Jean Fraser - Agreement with Concerns over 79 Walnut Street Proposal

I have reviewed the 79 Walnut street developer's submittal from the 2nd planning workshop. I would like the below considerations to be addressed and responded to accordingly during the next planning workshop which will be held next Tuesday, December 12, 2013 at 7:00pm in City Hall. I have also included the below in a MS Word Document to eliminate any potential format issues.

RETAINING WALL TYPES

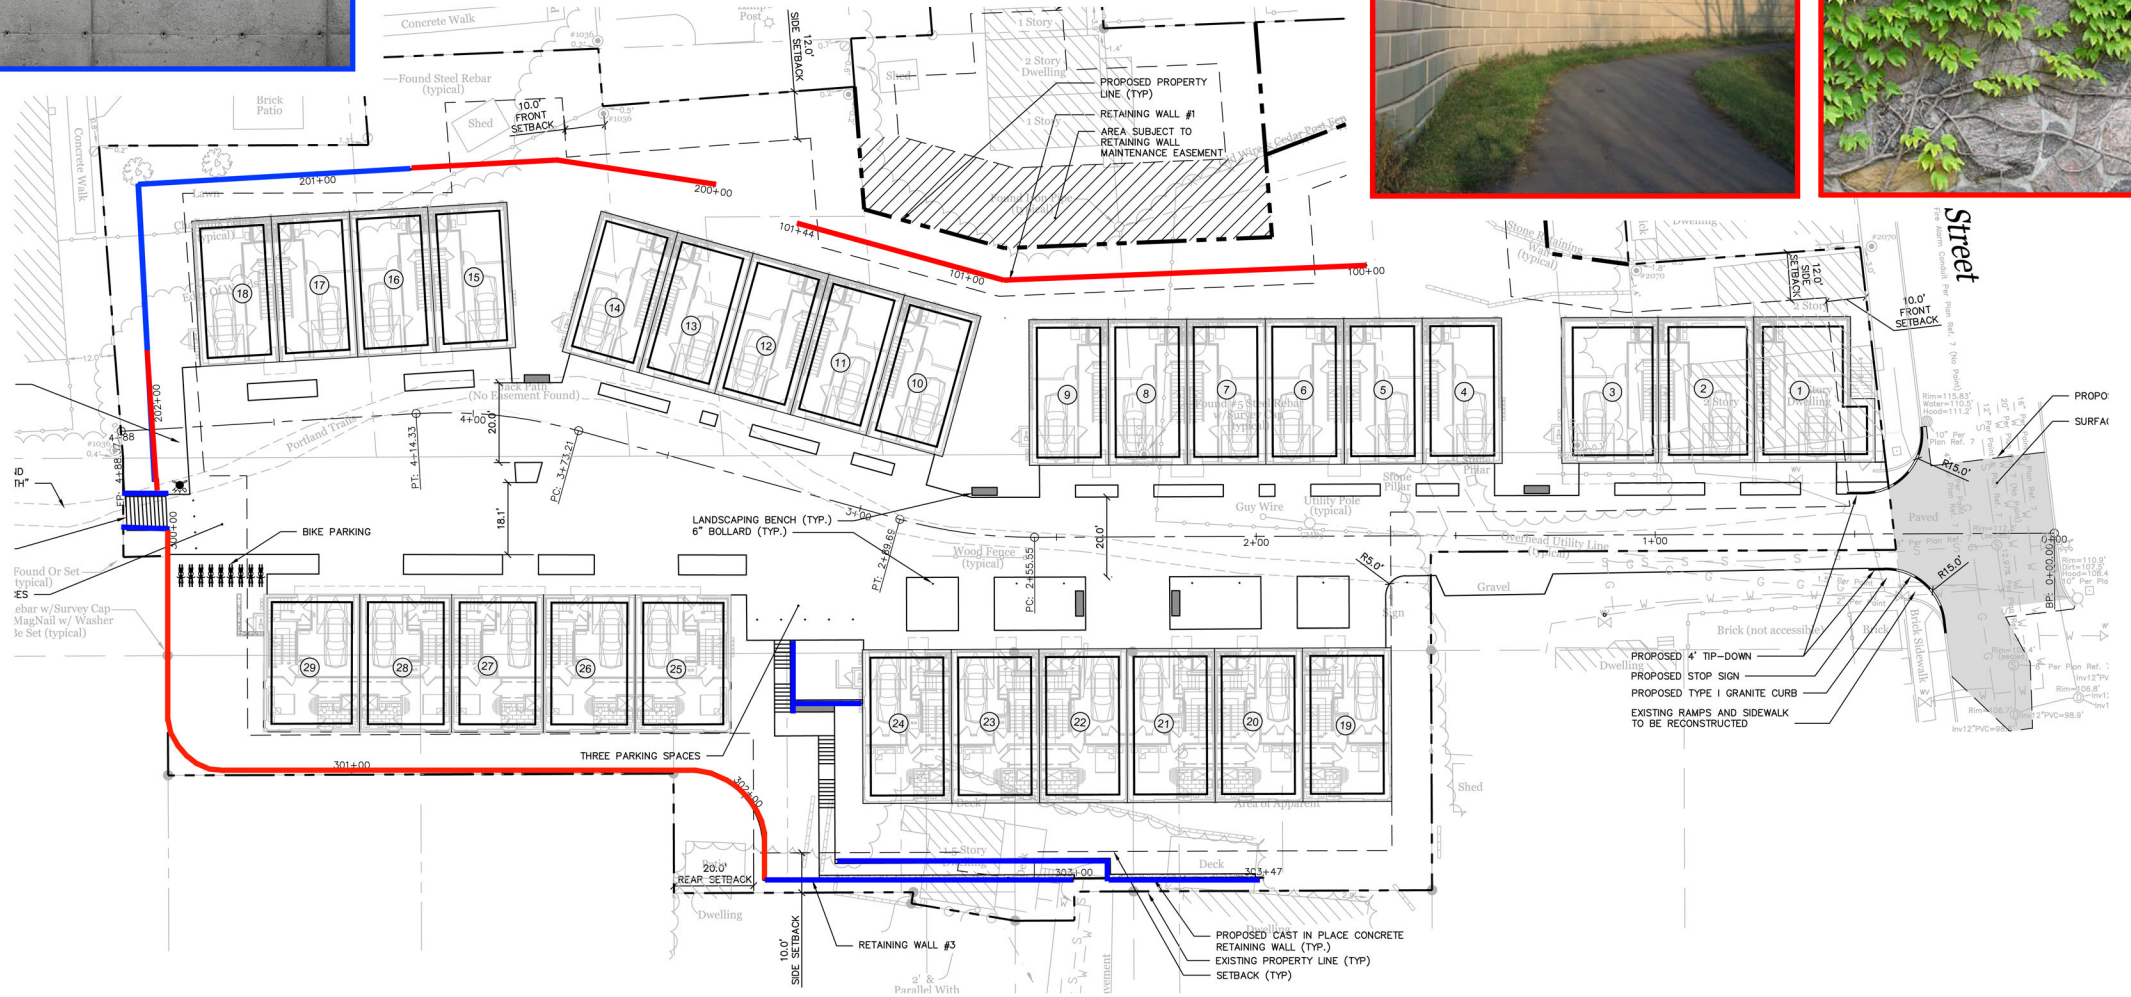
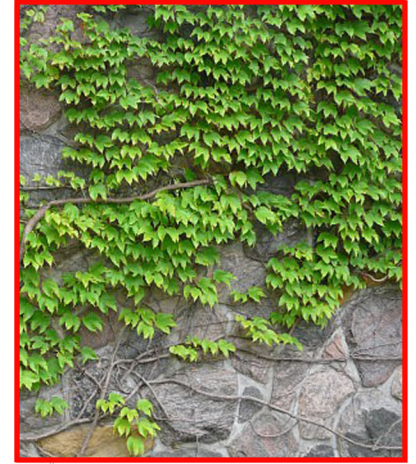
a) In Planning working #2, the developer provided a lot of pictures of retaining walls that will be used once the entire area is clear cut. The developer stated that a more detailed retaining wall design will be provided and approved by a Maine PE (Professional Engineer) once construction commences. It is requested additional erosion prevention design requirements are provided for this steeply sloped property that will be clear cut. An example of development on steeply sloped hills that have frequent mudslides is the city of Los Angeles where mud slides are common. It is common knowledge, that the

BEST answer to stop soil erosion are trees and not man-made unproven retaining walls.

DRAWING NO.
SN-1

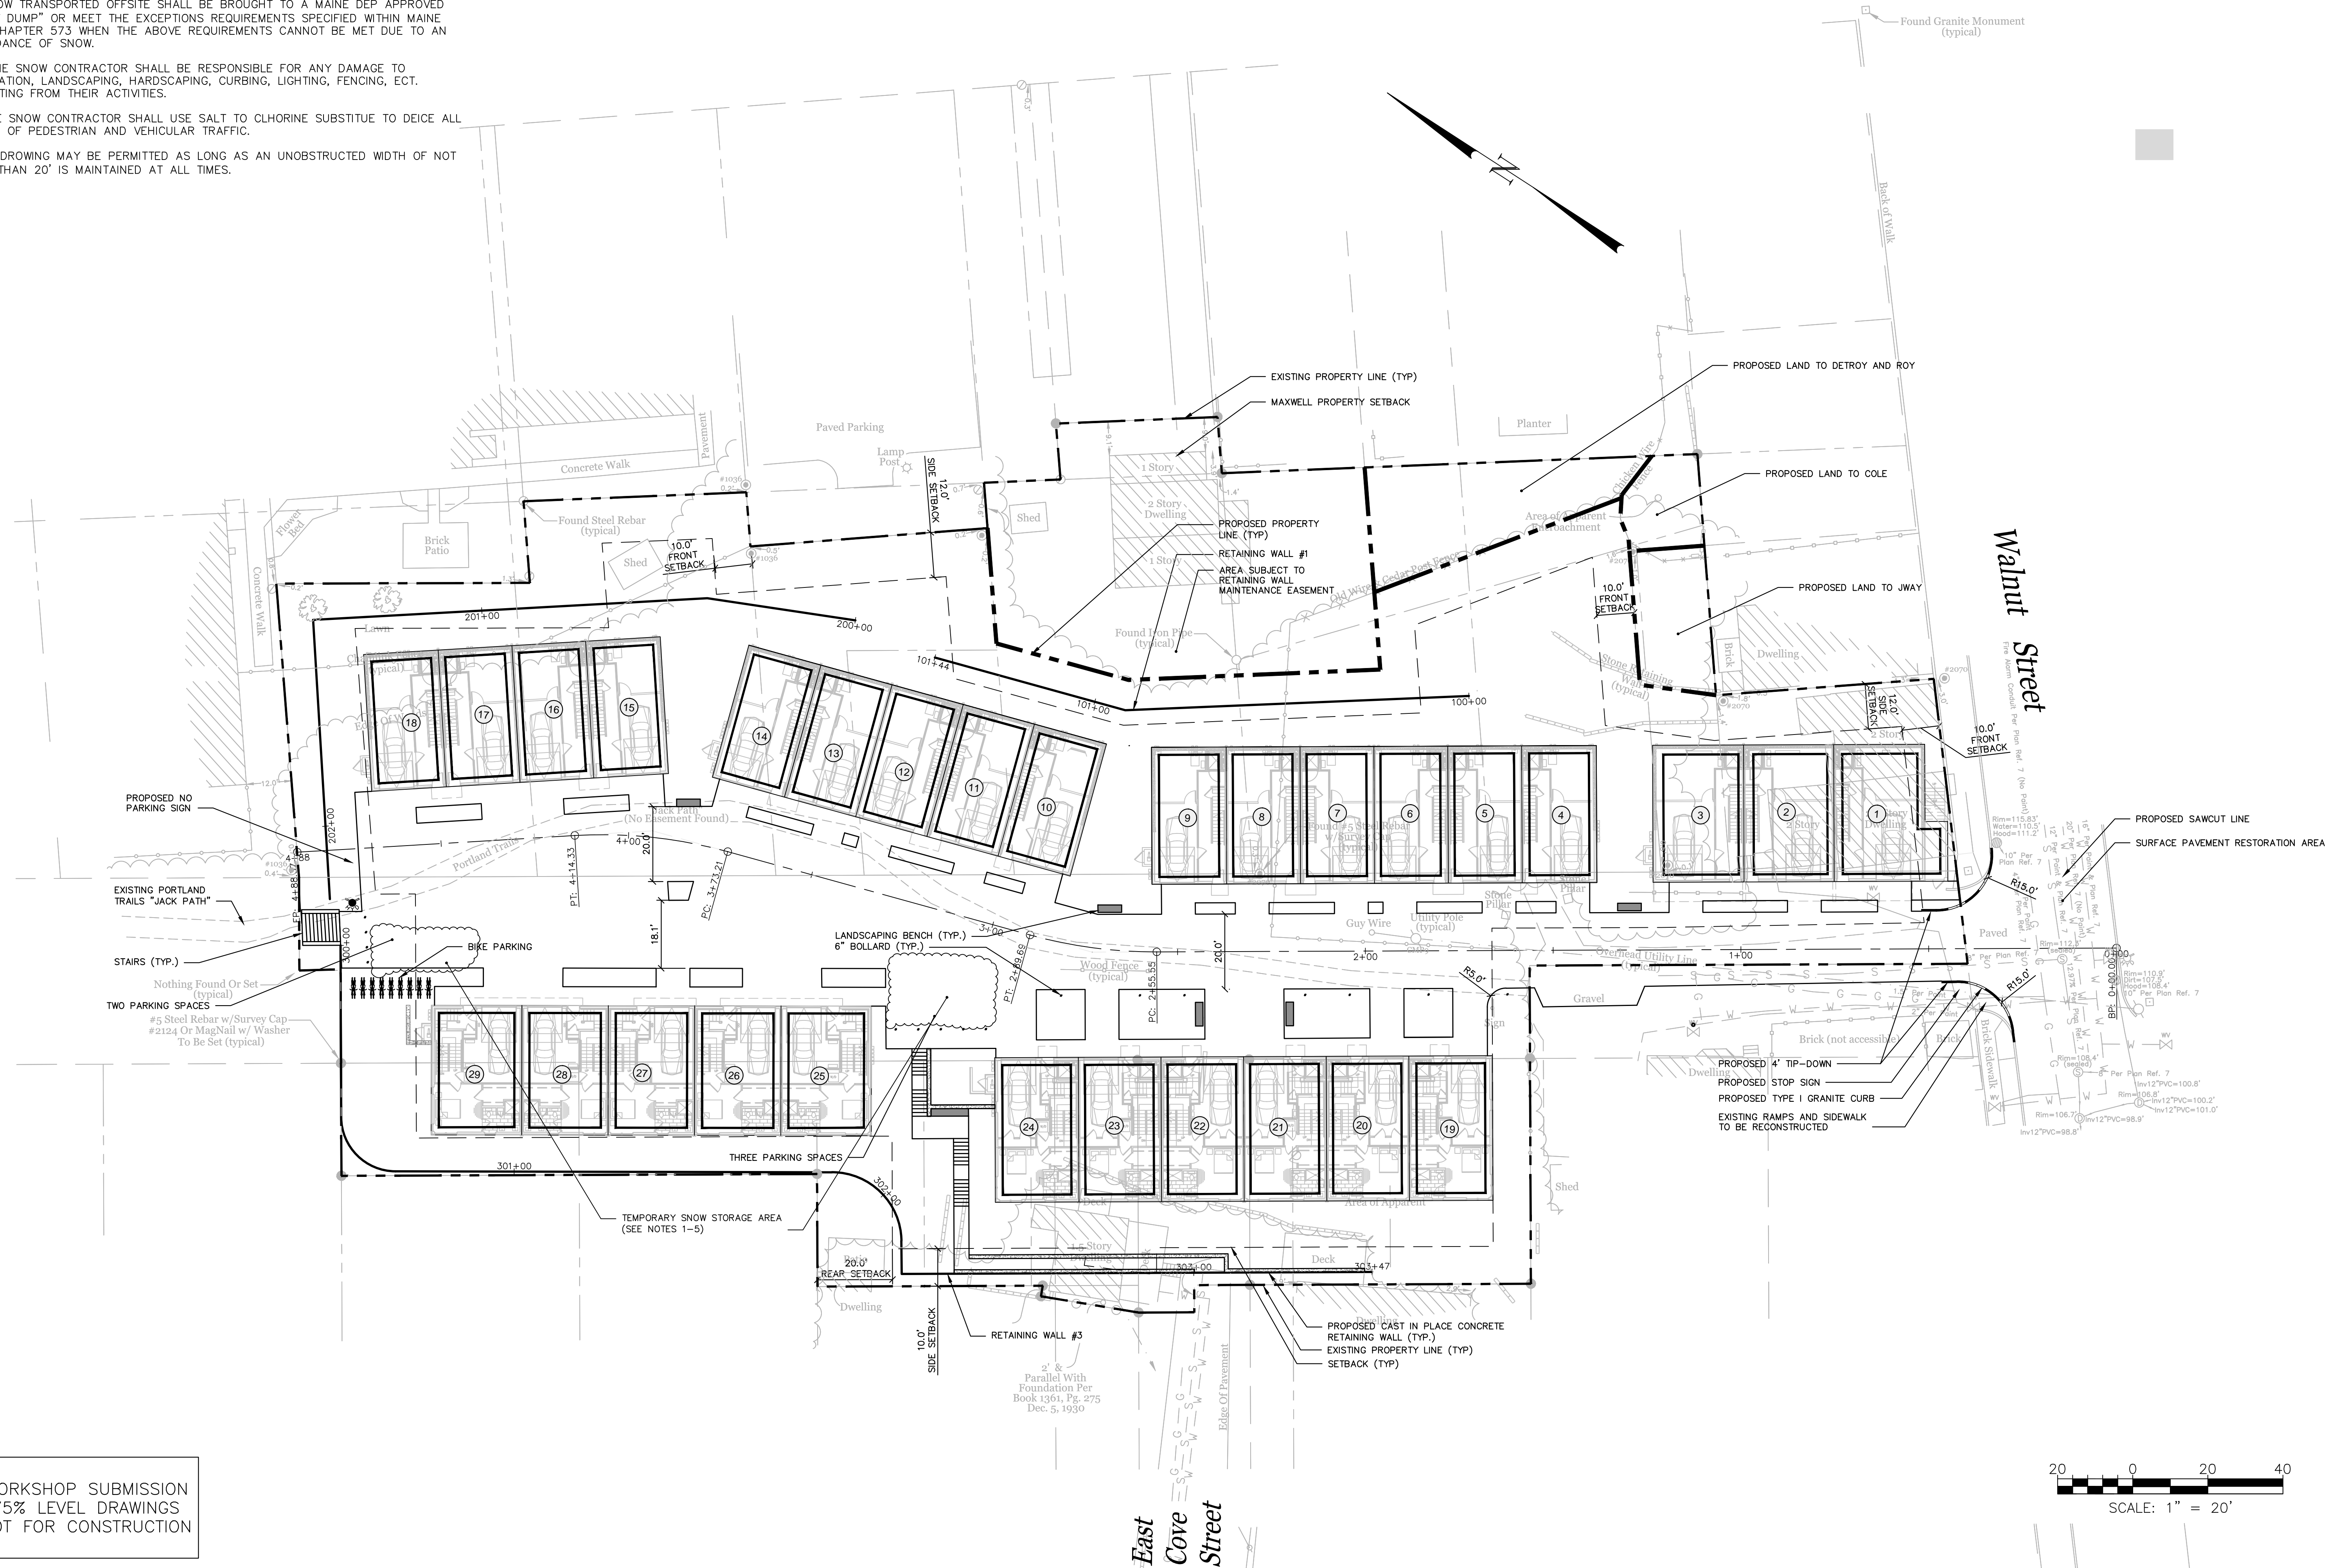
a) In Portland, ME, there is an average of at least 60" of snow annually. This is a challenge for the Portland snow plows which do an amazing job of removing snow off the streets and where the snow is to be stored. In the previous 2 workshops, there was no mention or explanation of snow storage or a snow removal plan for this development. It is recommended that additional study is needed to address this issue.
